# Bramford to Twinstead Reinforcement

Document 8.5.3.3: Applicant's Comments on Babergh District Council  
Additional Local Impact Report

Final Issue A  
October 2023

Planning Inspectorate Reference: EN020002

TITLE  
 2.11.7 DESIGN AND LAYOUT PLANS: STOUR VALLEY EAST CABLE SEALING END COMPOUND

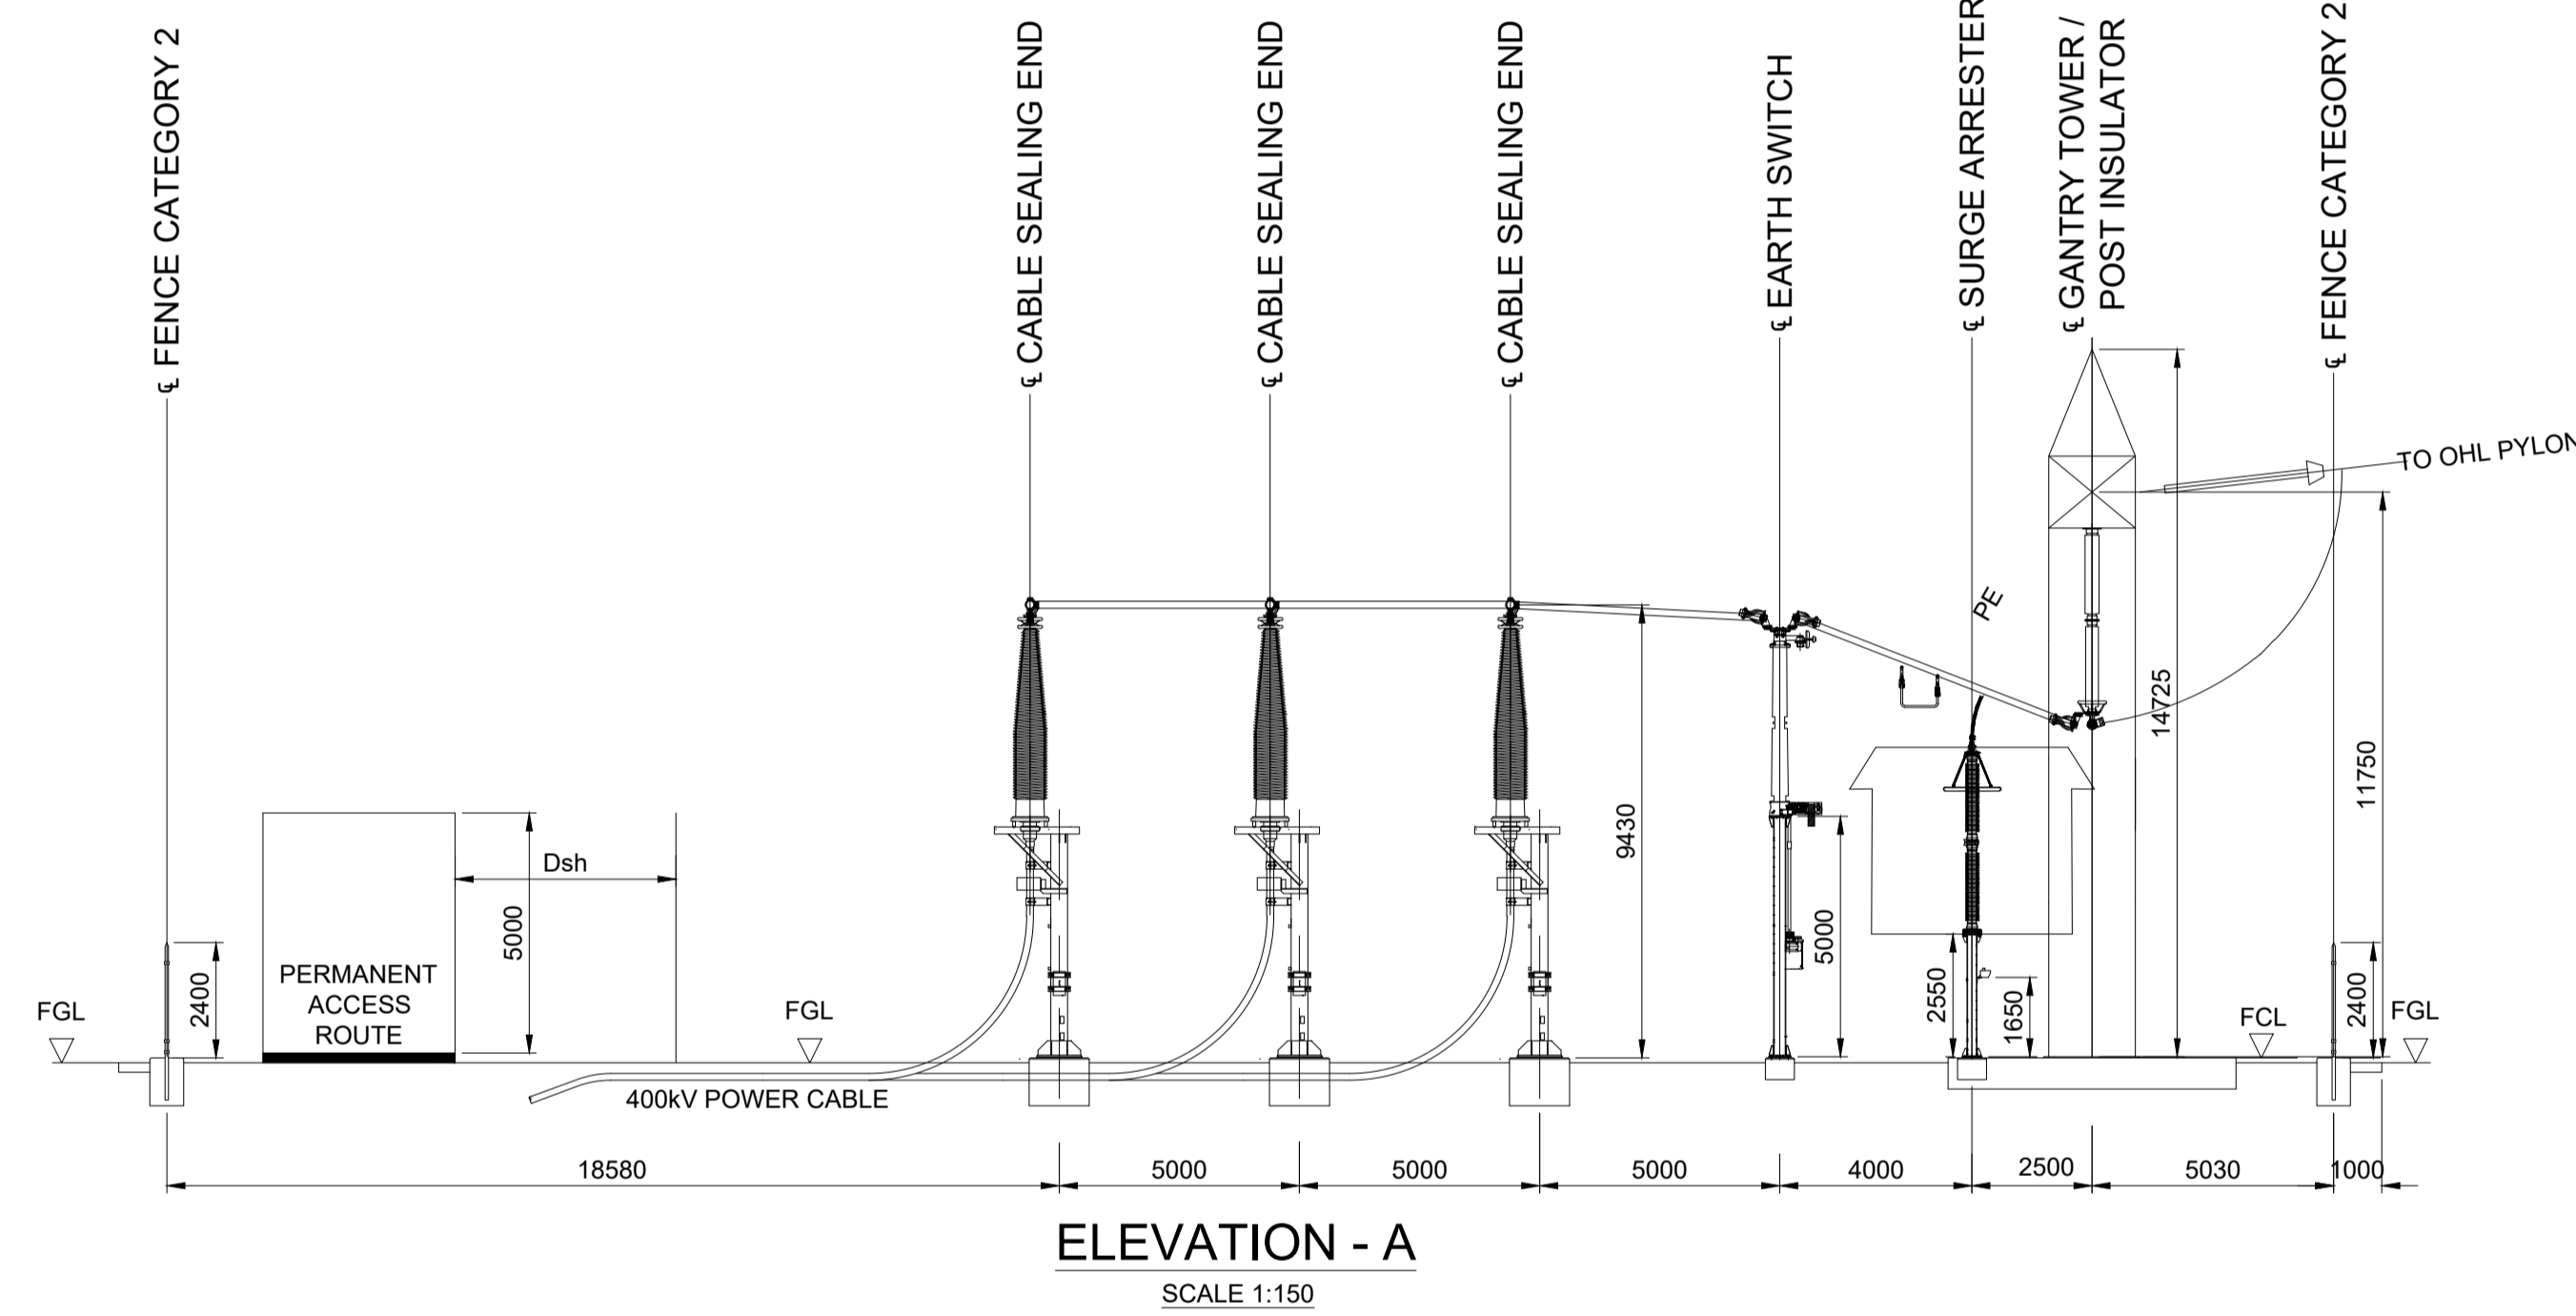
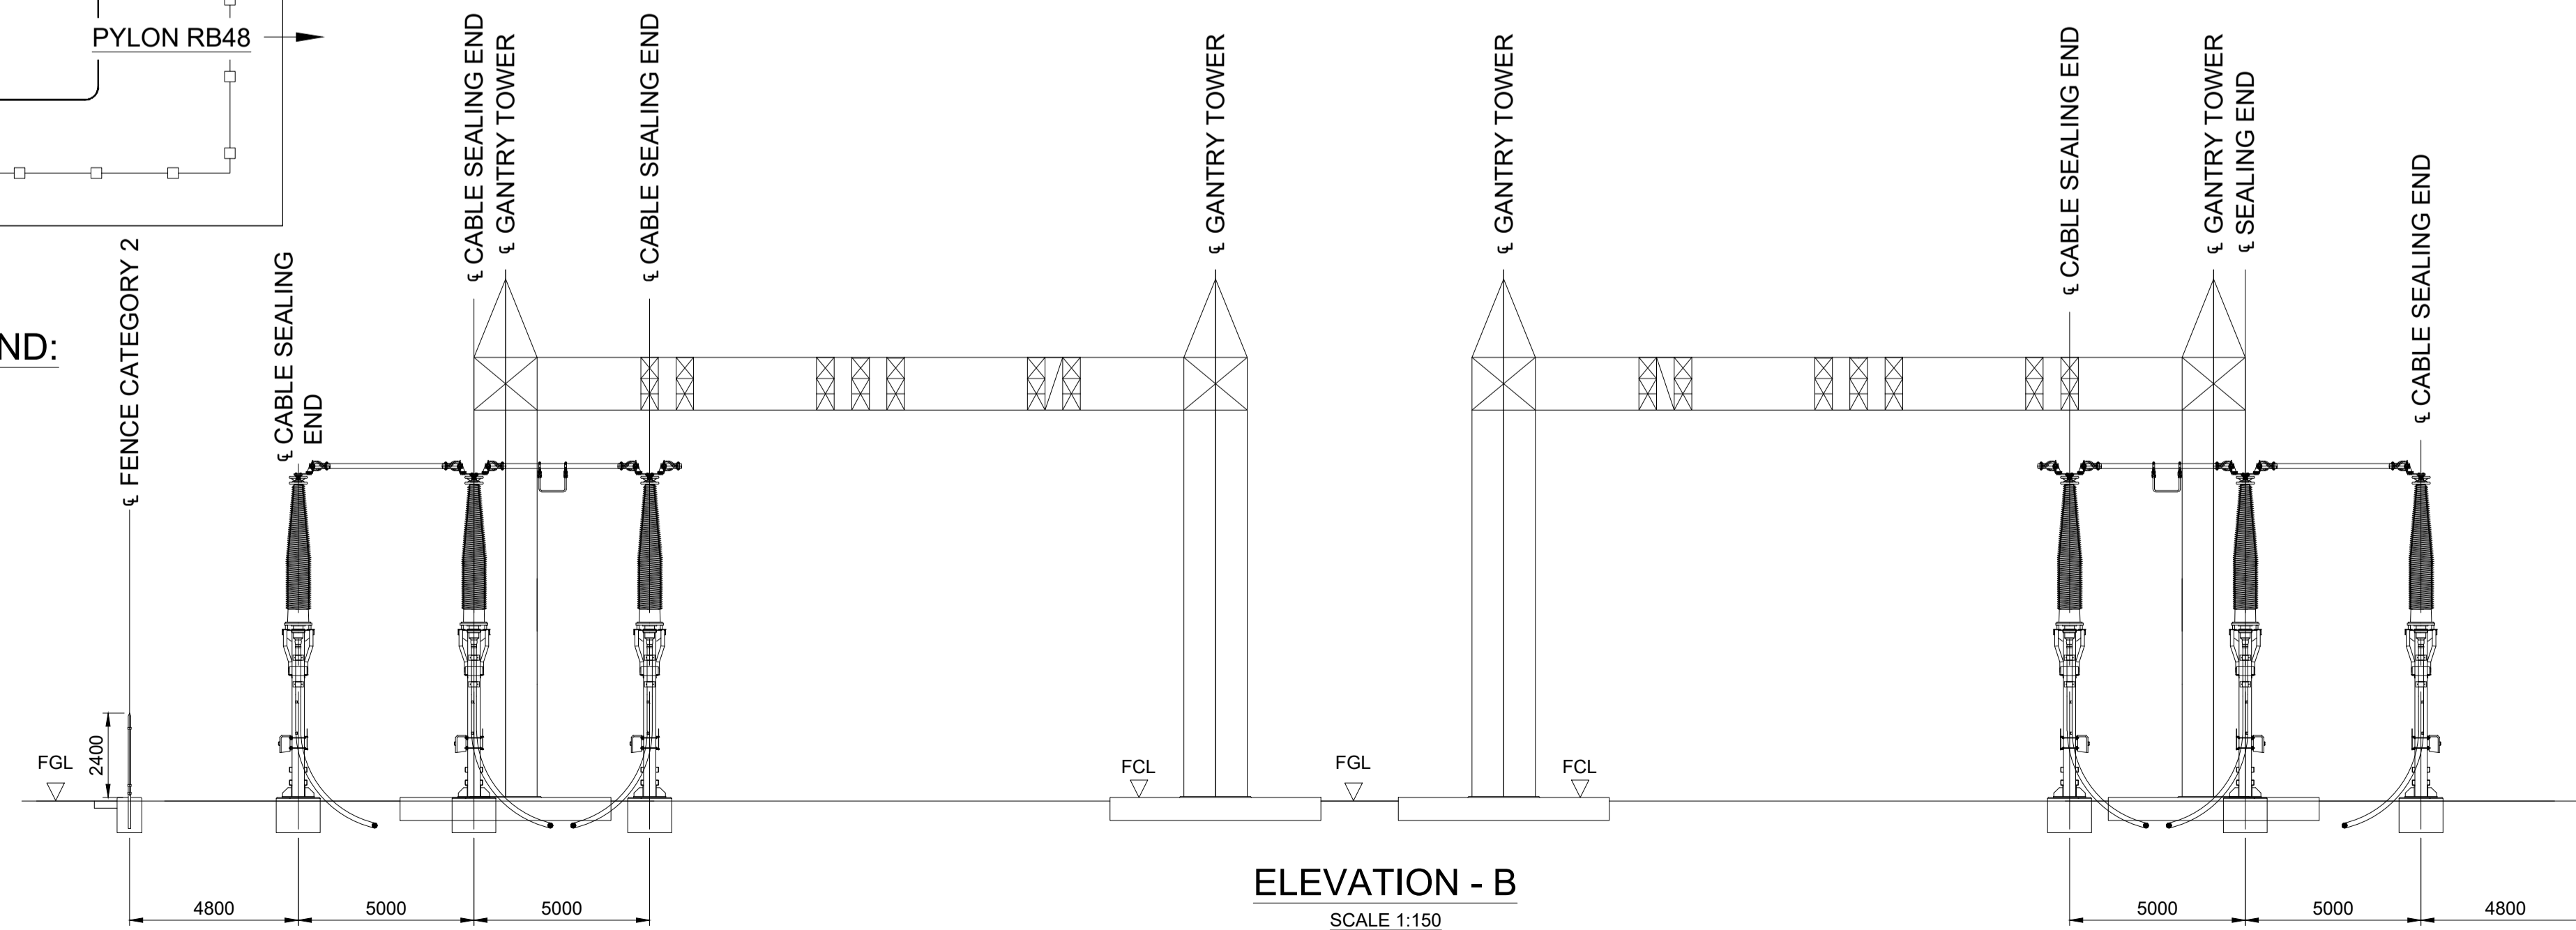
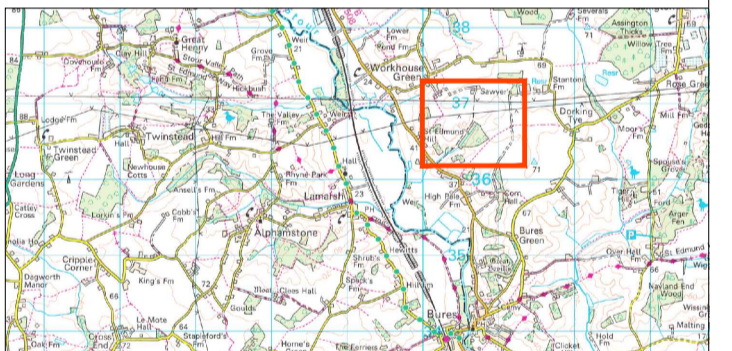
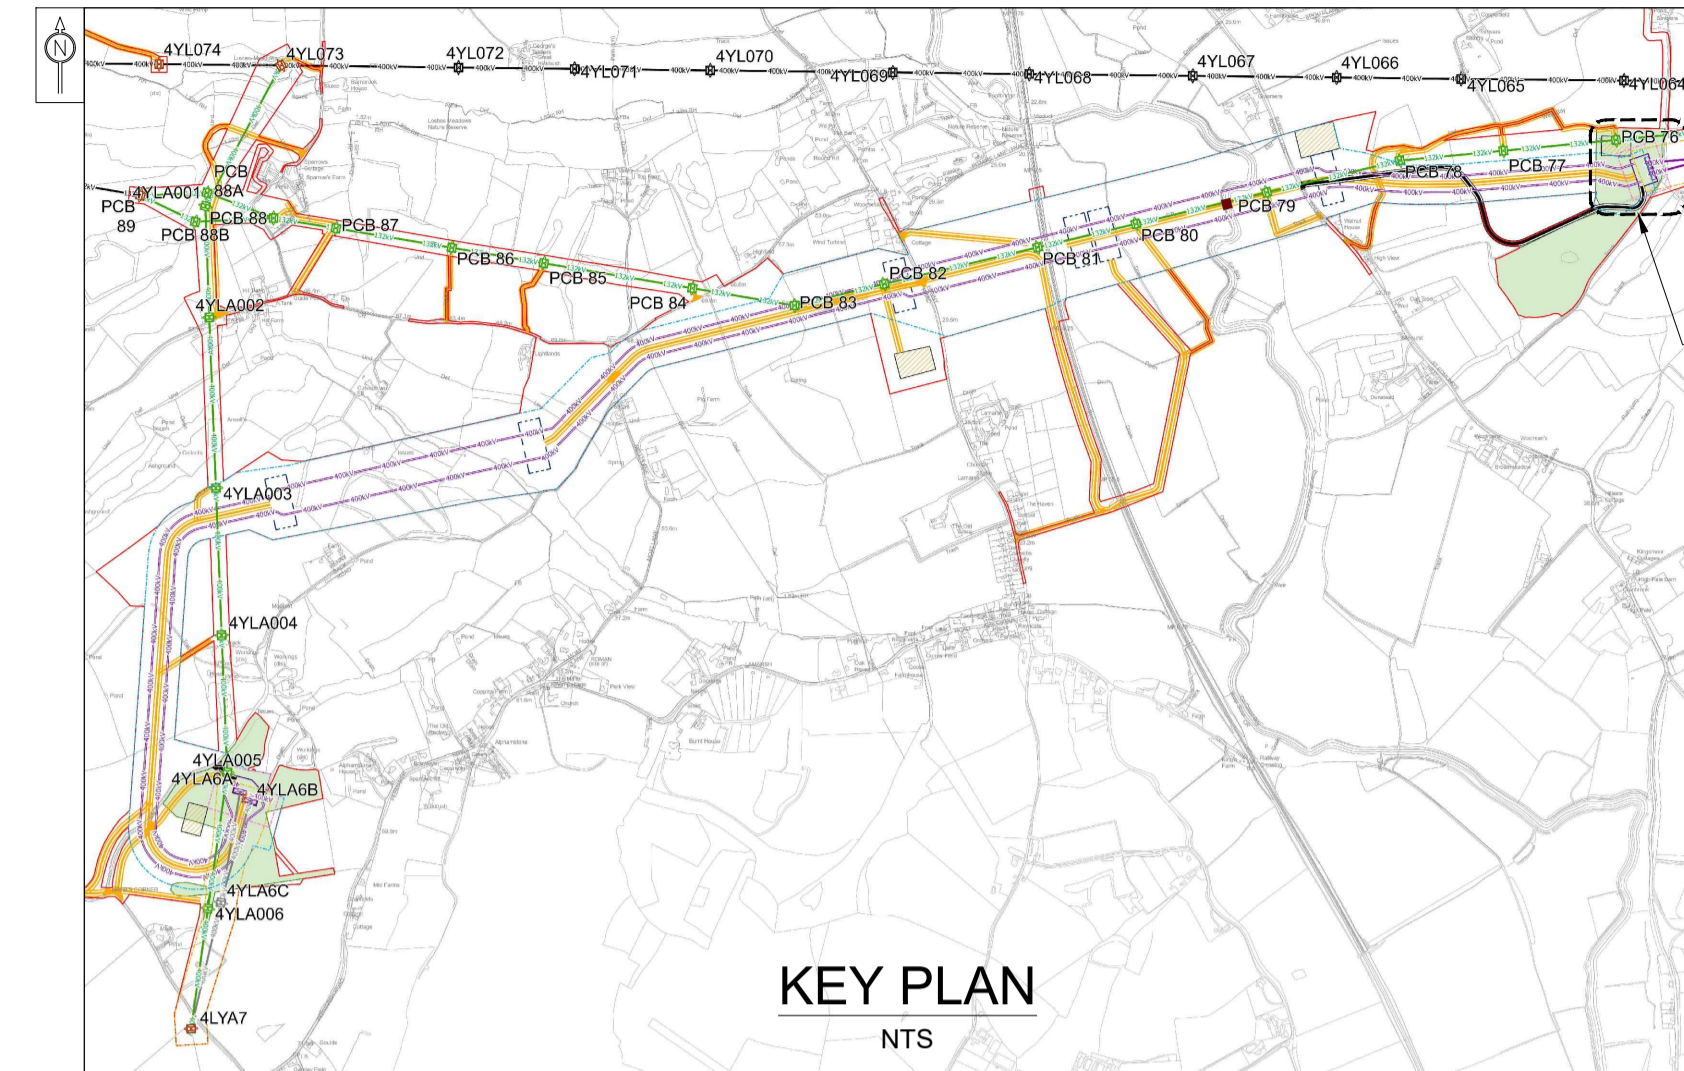
Reference	Point Raised	Applicant's Comments
2.2	<p>The Typical Design and Layout Plans for the Stour Valley CSE Compound (Figure 3.3.4 Typical Design and Layout Plans: Stour Valley East CSE Compound January 2022) do not show the proposals in their context, nor indicate possible mitigations, making landscape and visual effects hard to judge. The compound structures are approximately 37.4m x 74.1m x 14.3m to the top of the gantries.</p>	<p>The viewpoint assessment for the Stour Valley is presented at ES Appendix 6.4: Viewpoint Assessment Section G Part 6 <b>[APP-106]</b>. The photomontages for relevant viewpoints are presented at Photomontages Appendix 3 Part 3 <b>[APP-065]</b>.</p> <p>The photographs provided for viewpoints G-02, G-03, G-04, G2.5 and G-24 <b>[APP-106]</b> and the photomontages for viewpoints G2.5 and G-24 <b>[APP-065]</b>, illustrate how from most locations, the topography and existing vegetation would screen and filter views of the CSE compound including the gantries, which are the tallest part of the compound infrastructure. Viewpoint G2.5, although at some distance, was one of the few locations identified which would have visibility of the gantries. The photomontage prepared for this viewpoint <b>[APP-065]</b> shows that by Year 15 the gantries would be barely discernible in this wide view from the Stour Valley. This is due to the existing vegetation and embedded planting, which by Year 15 would be maturing.</p> <p>The proposed planting at the CSE compound is shown on Sheet 19 of LEMP Appendix B: Vegetation Reinstatement Plan (<b>document 7.8.2(B)</b>).</p>

2.4 – 2.5	<p>The compound is on a high point (c 60m AOD) so has the potential for high visibility (See Photomontages). The visual effects could have been assessed from the PRoW to the west of the compound (c550m away), or from the</p>	<p>A viewpoint selection document presenting representative viewpoints proposed for the assessment was issued to SCC and BMSDC on 16 June 2021 following a meeting in May 2021 and locations were updated in line with comments received. No additional viewpoints were requested by SCC and BMSDC.</p>

Reference	Point Raised	Applicant's Comments
	<p>southeast (c400-600m away) and from Workhouse Green to the northwest (c600m away).</p> <p>Whilst the visual effect of the compound is not significant from VPG2.5 as it is c2km away, this viewpoint is not representative of the experience of people using the PRow network closer to the compound, nor does it demonstrate the effects on the local landscape itself or its fabric. The assessment approach does not appear to consider the character of the cultivated fields (as opposed to the structures, woodlands, trees or hedgerows found on or around them) as part of the fabric of the landscape which is an omission.</p>	<p>The effects of the proposed Stour Valley East CSE compound on the landscape are presented at ES Appendix 6.2: Assessment of Effects on Designated Landscapes <b>[APP-098]</b>. This includes the eastern part of the SLA where the Stour Valley East CSE compound is located. Section 3.6 of this document states that, due to the removal of the existing 132kV overhead line in association with the proposed undergrounding, the long-term residual effect on the landscape would be moderate beneficial (significant) locally within approximately 1km of the LoD and minor beneficial (not significant) for the SLA as a whole.</p> <p>The proposed Stour Valley East CSE compound is located within the Bures St Mary community area. Section 2.7 of ES Appendix 6.5: Assessment of Effects on Communities <b>[APP-108]</b> presents the assessment of visual effects on this community area and includes the relevant viewpoints. Paragraph 2.71 includes reference to the relatively sparse PRow network but notes that the latter includes St Edmund Way and The Painters Trail. The assessment concludes that due to the removal of the existing 132kV pylons, the long-term residual effects of the Project on this community area would be minor beneficial (not significant). The effects on the Rolling Valley Farmlands in which the proposed Stour Valley East CSE compound is sited are presented at ES Appendix 6.3: Assessment of Effects on Landscape Character <b>[APP-100]</b>. The assessment takes account of landscape character which includes the physical attributes of the landscape (i.e. its elements and features) as well as its overall composition, character and how this is perceived. Section 3.1 of this document concludes that the long-term residual effects on LCA 1e would be minor beneficial (not significant). This is because the embedded planting around the Stour Valley East CSE compound in LCA 1e would be maturing and both screen the infrastructure and integrate it into the wider landscape. Similarly, the reinstatement planting associated with the 400kV underground cables would be maturing and the landscape would be returning to its existing character.</p>

2.6	<p>The CSE Compound appears to be theoretically visible over a wide area. The Zone of Theoretical Visibility (ZTV) shows that there are potential effects of the mid-height of the gantries in the compound from the B1508 from around 700m away. In addition, widespread although distant visibility is indicated west of the railway line, around Alphamstone in the west, St Edmund's Path/Stour Valley Path west of Henny Road, and around Lamarsh. Most of these effects fall within the SVPA.</p>	<p>The ZTV presented on ES Figure 6.11 <b>[APP-147]</b> shows the limited visibility of the CSE compound, with no locations being able to see the full CSE compound and only limited areas being able to see the top half of the gantry. Although the ZTV takes account of some vegetation, woodland being mapped using National Inventory of Woodland, it does not take account of the screening and filtering effects of individual trees and hedgerows which would further reduce the visibility of the gantries within the CSE compound.</p>

- 2.3.7 The Stour Valley East CSE compound is sited in a location that limits the effects on the surrounding landscape and visual receptors and is not very visible from the PRoW closest to the location, the nearest being over 300m away. The most open views of the Stour Valley East CSE compound are from the western side of the River Stour and these more distant views are heavily filtered by vegetation in the majority of locations. When visible, the Stour Valley East CSE compound would only form a very small proportion of the view and embedded planting would screen all but the tops of the gantries when mature.
